Ms Claire Muir
Town Planning Advisor
Health Infrastructure
1 Reserve Road
St Leonards NSW 2065
12/11/2021

**The Children's Hospital at Westmead - Paediatric Services Building (SSD-10349252)
Request for additional information**

The Department has reviewed the Amendment Report (AR) and Response to Submissions (RtS) submitted for The Children's Hospital at Westmead - Paediatric Services Building (SSD-10349252) and requests that a response be provided to the Council and EPA comments on the documents (attached). You are also asked to address the following:

Sheet Name ELEVATIONS - SHEET 02		
Scale 1 : 500@A1	Date 19/11/21	
Drawn By LL	Checked By AF/IKK	Revision H
Project No	19038	
Drawing No CHW-AR-DG-PSB-SSD031

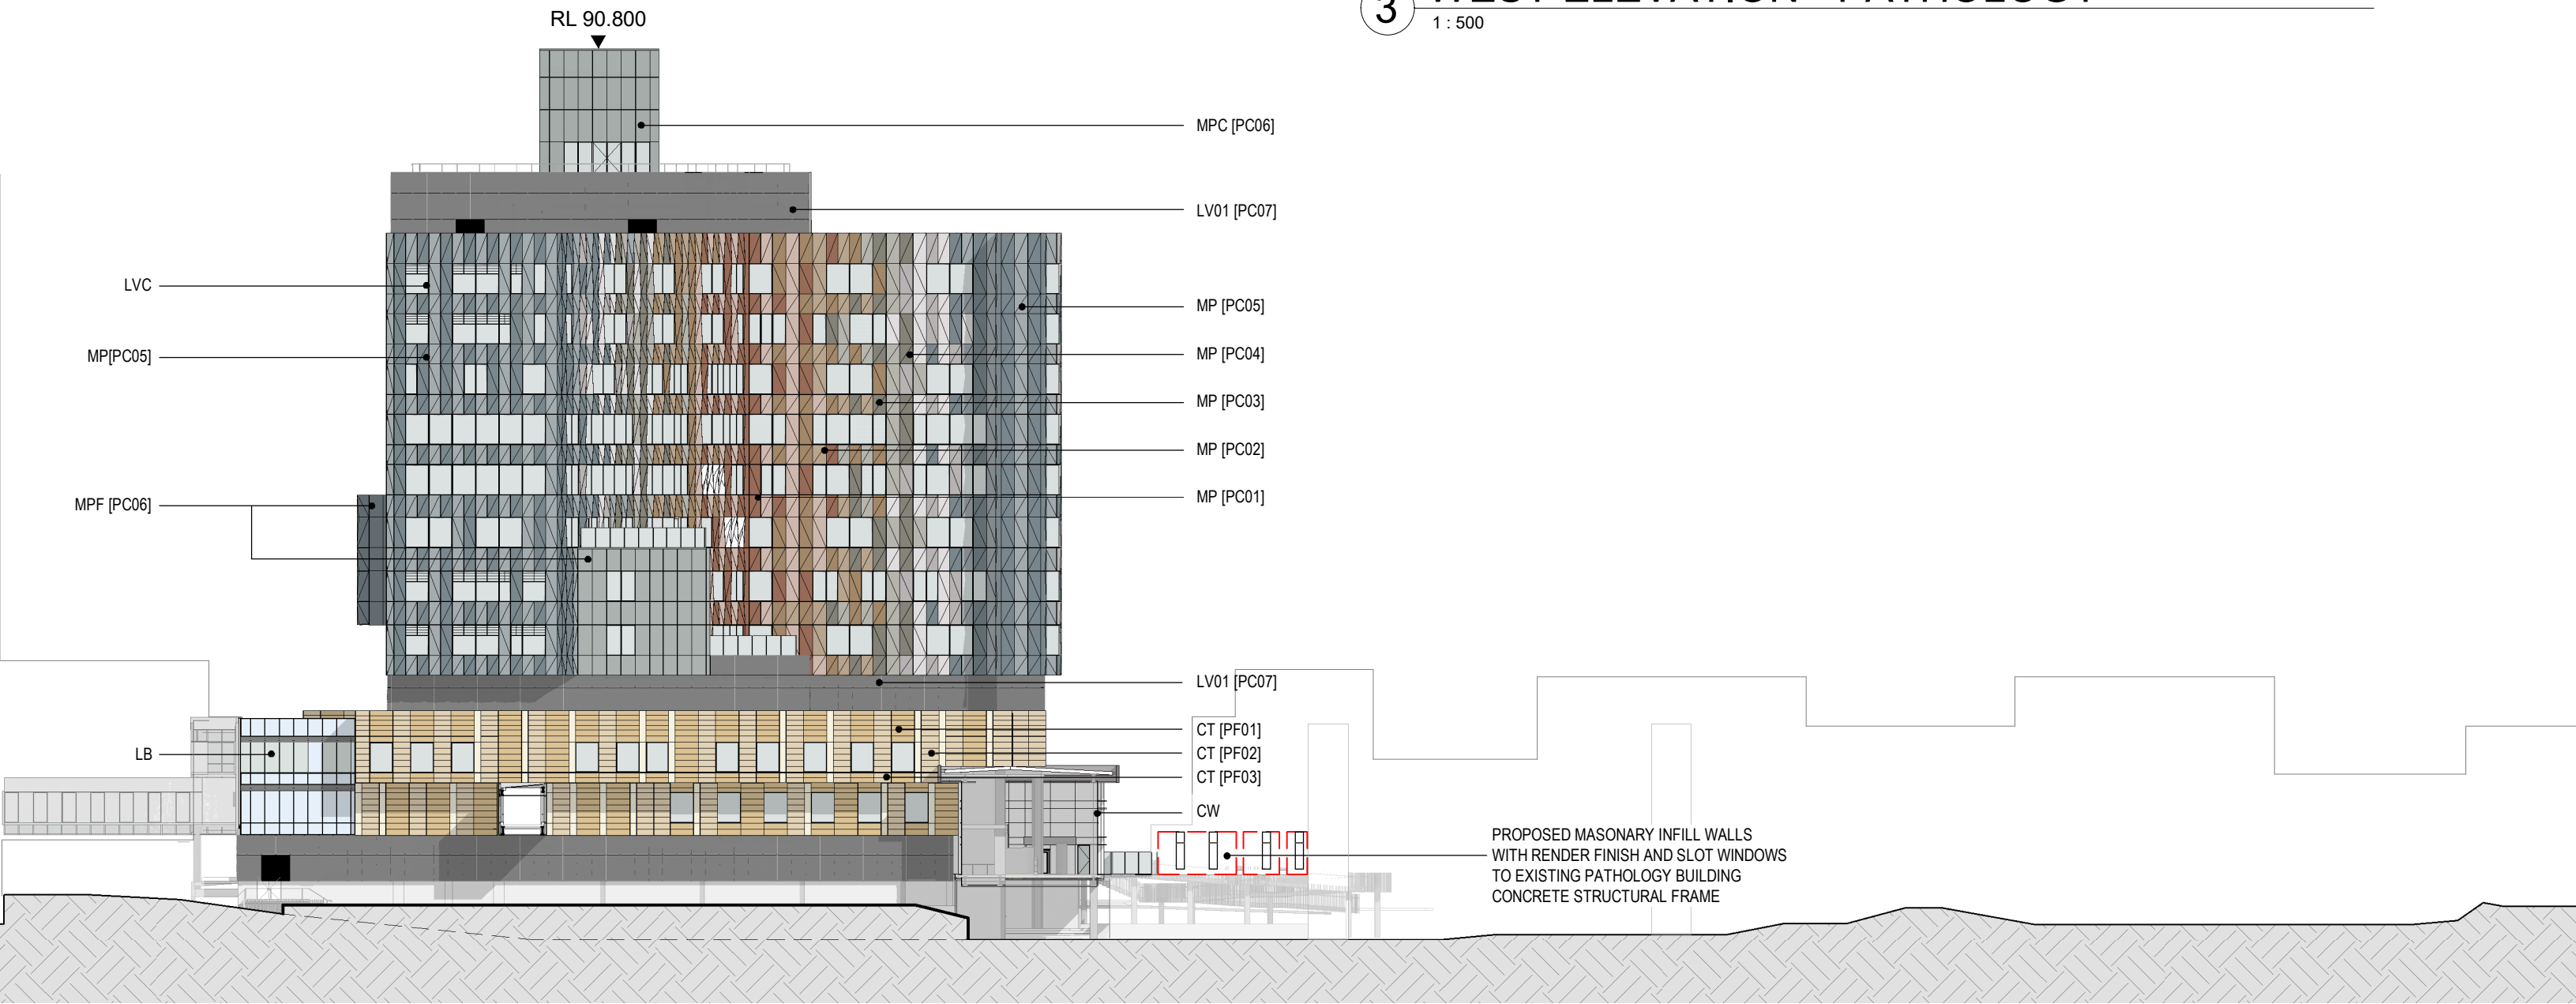
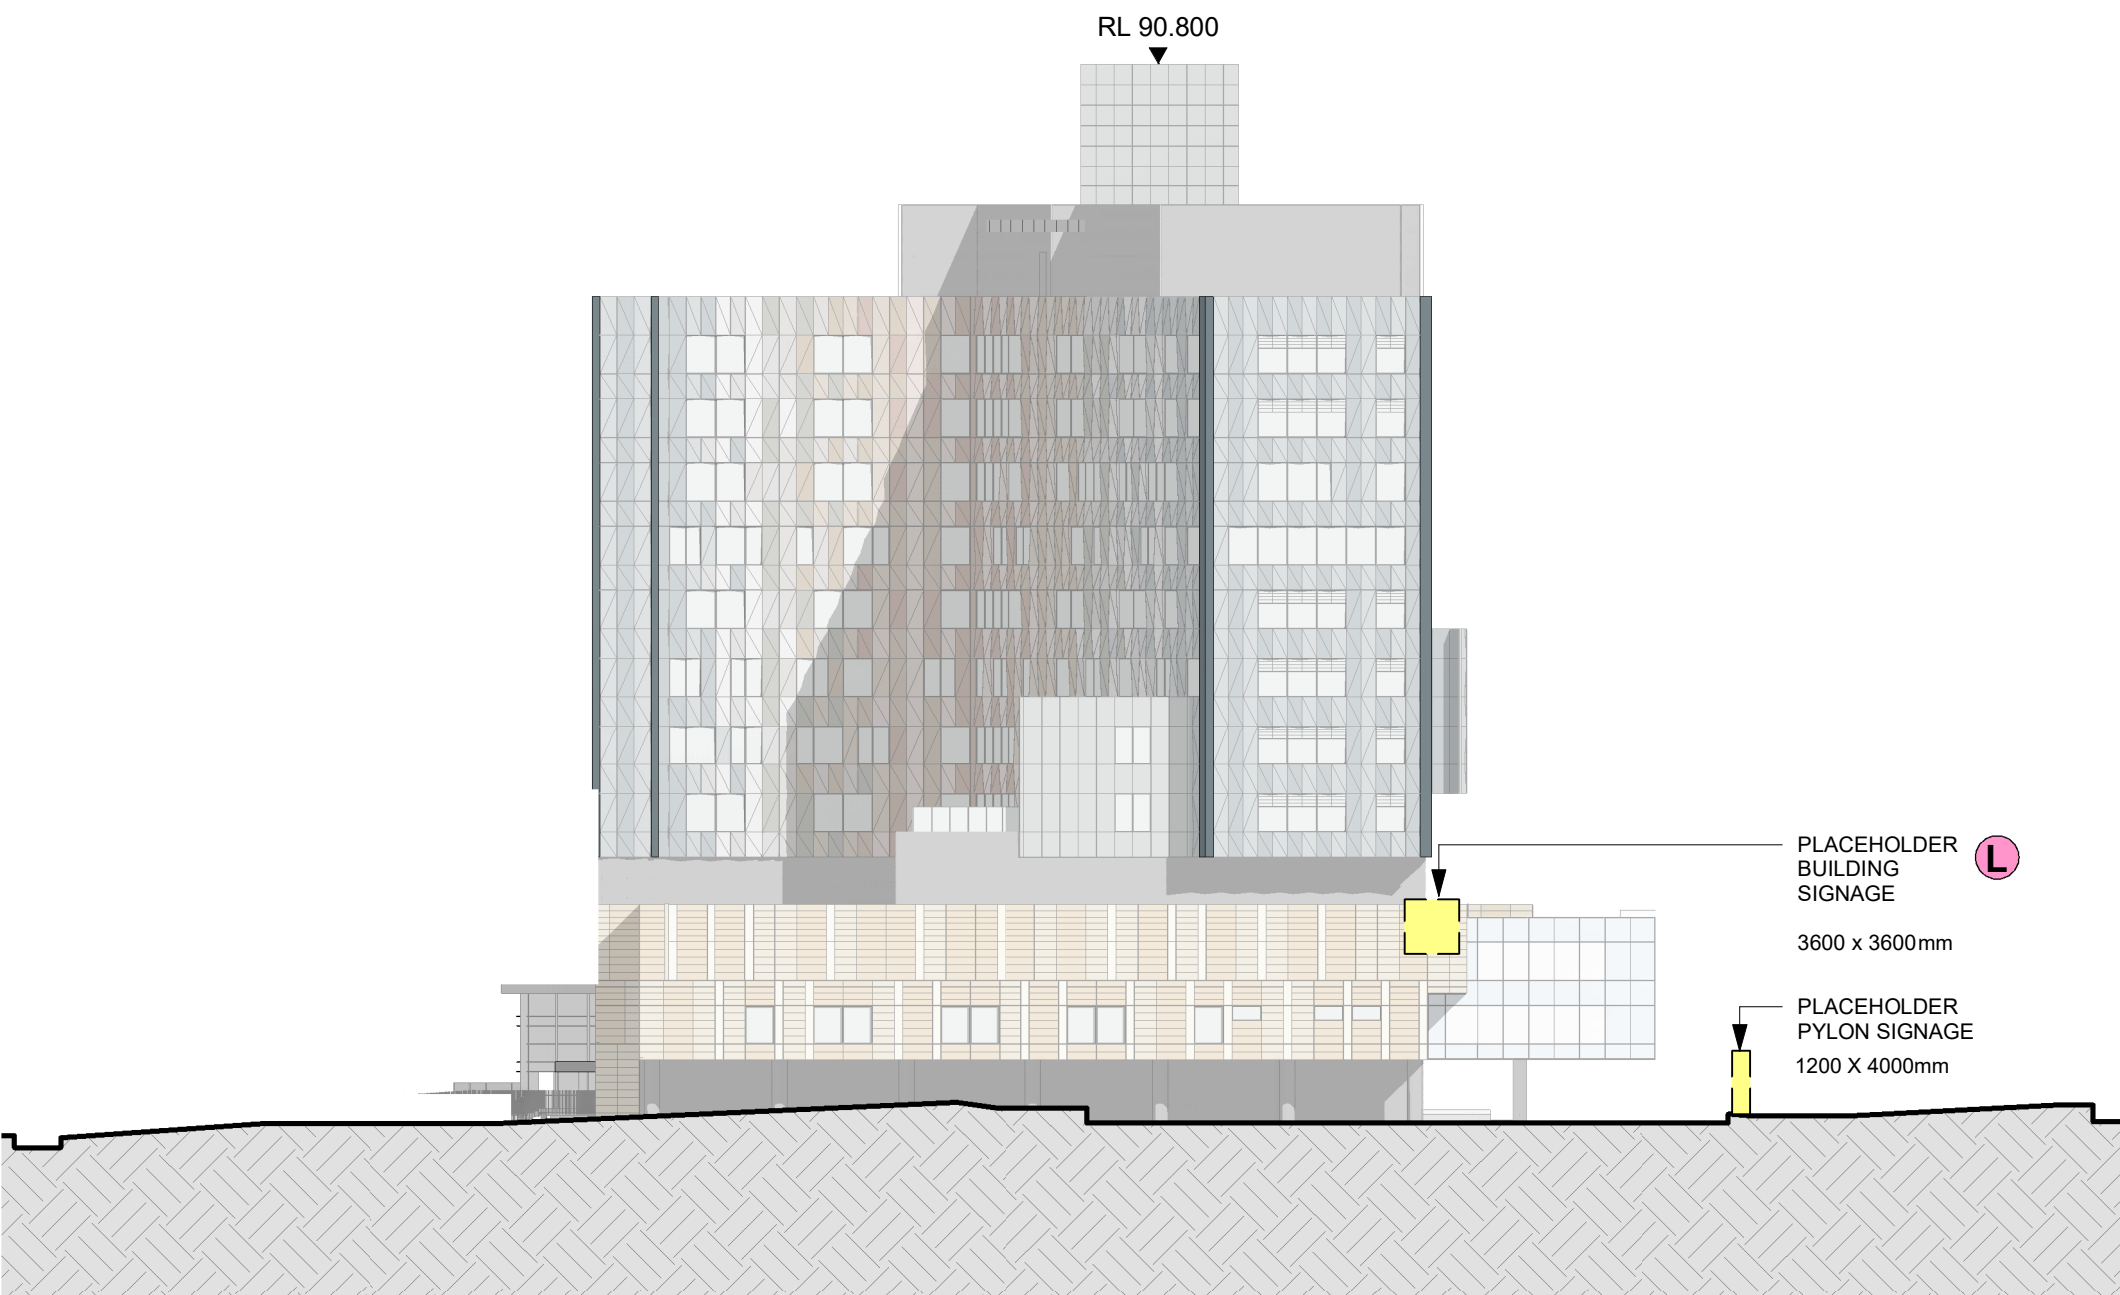
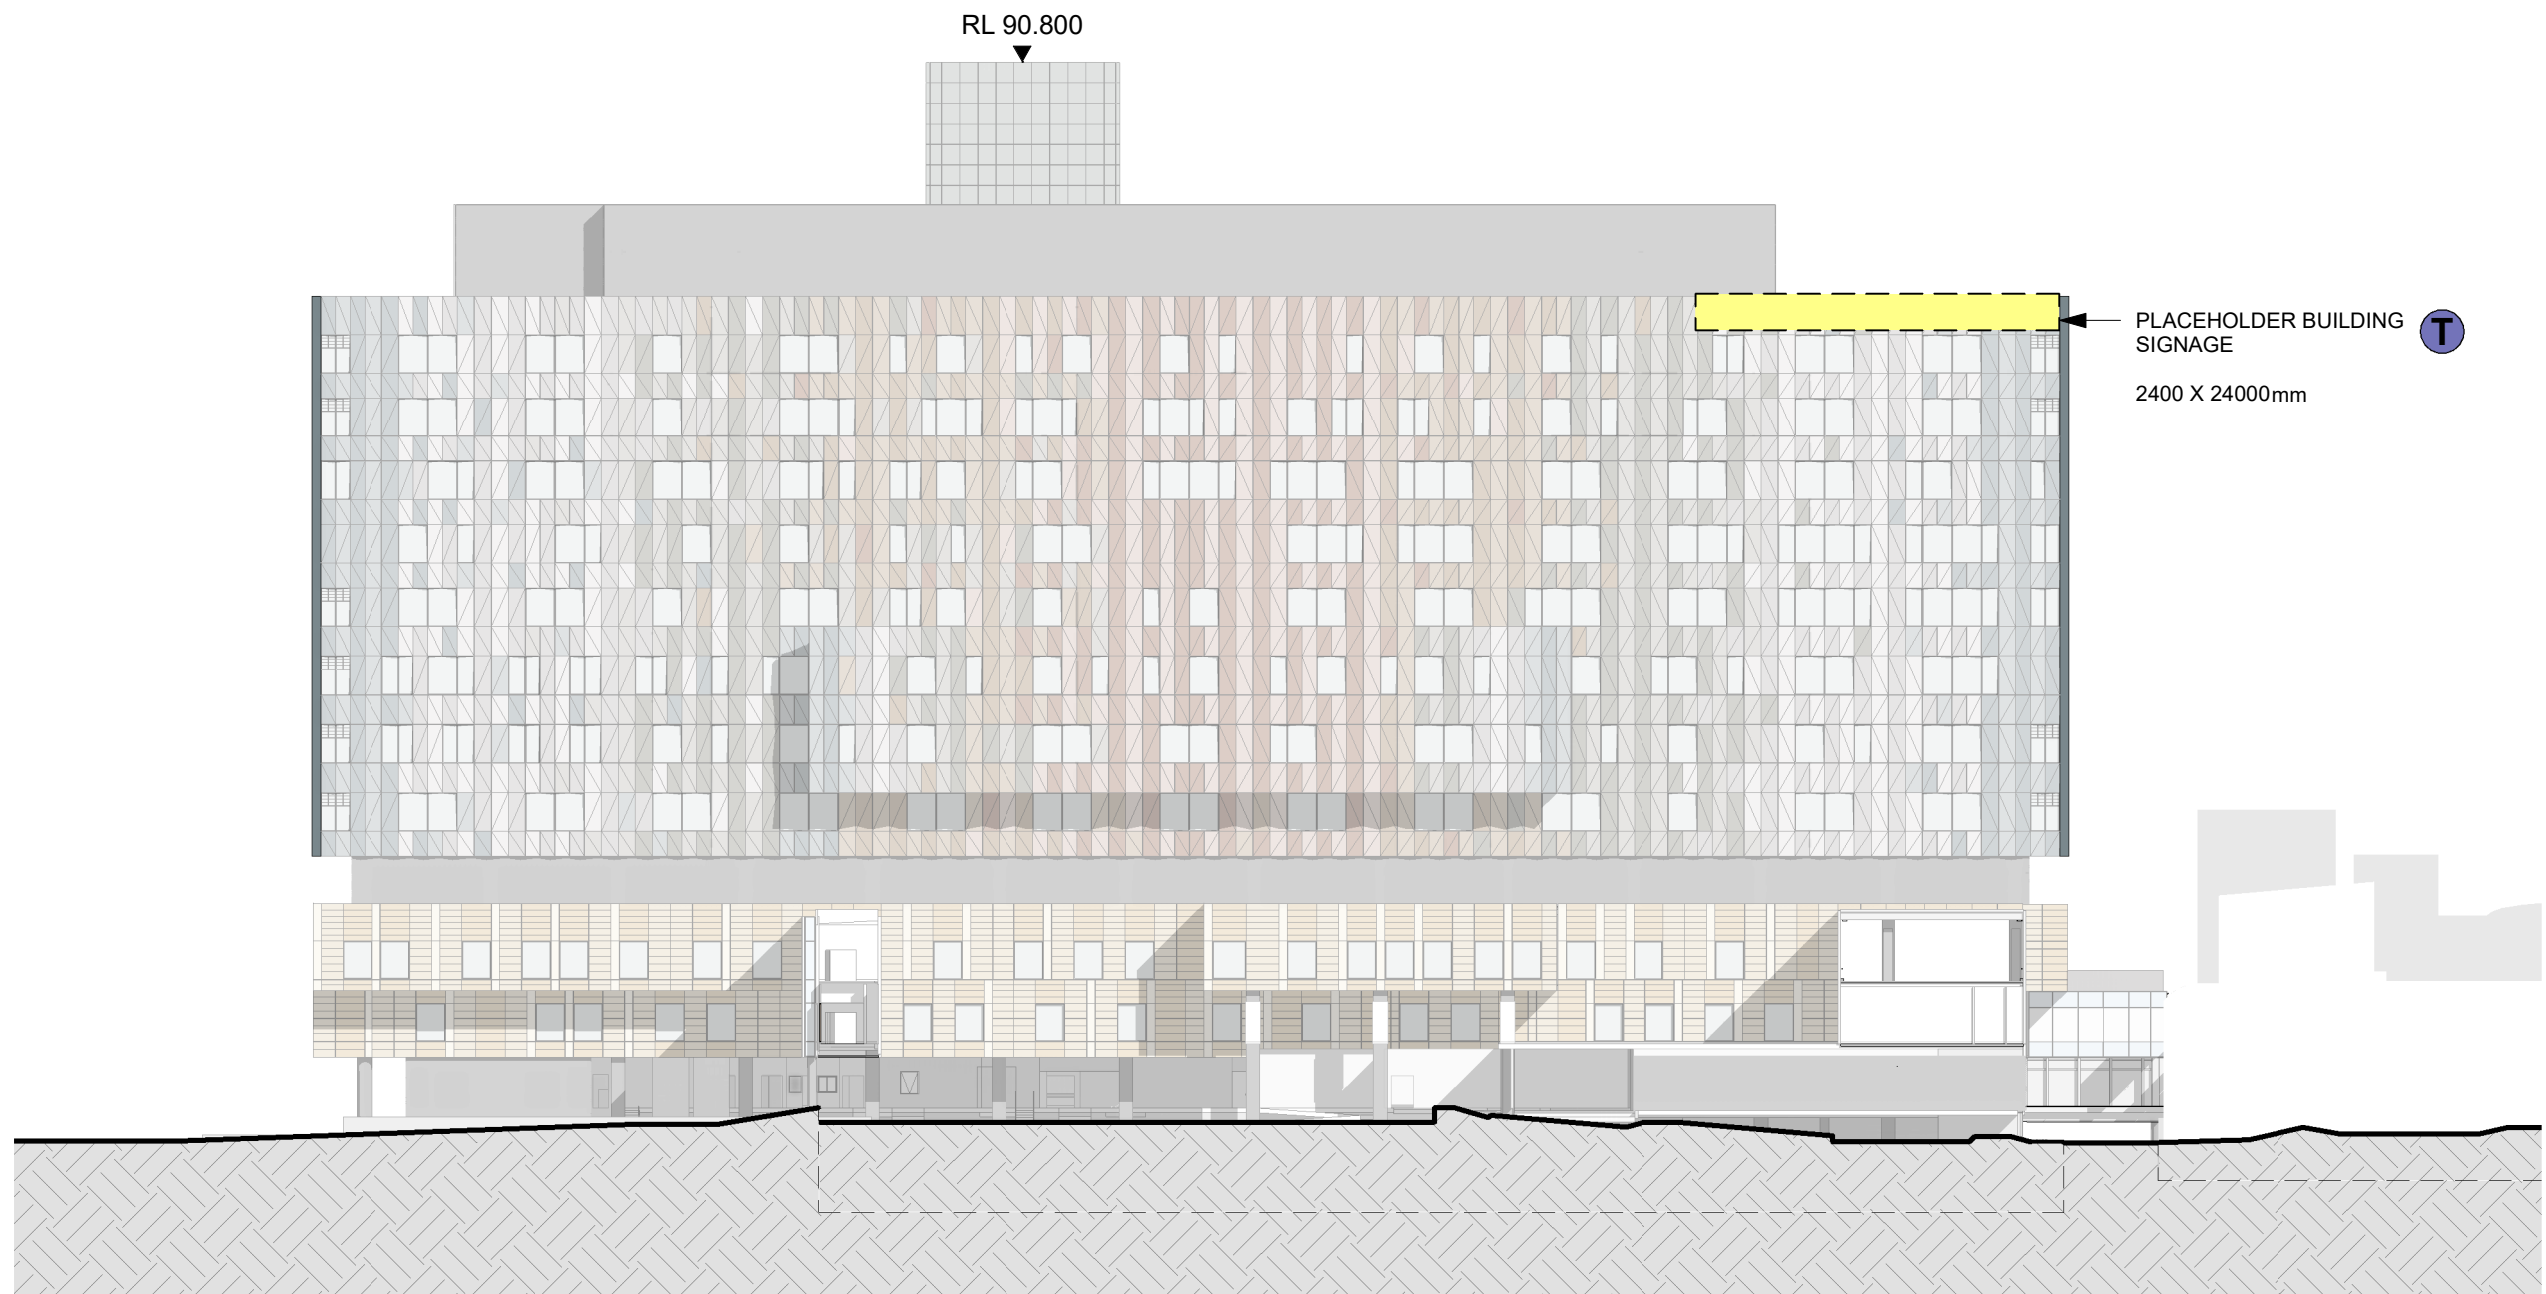
- provide updated architectural plans showing a consistent building height - the elevations currently detail a maximum building height of RL90.800, while the floor plans and Amendment Report detail a maximum building height of RL90.750.
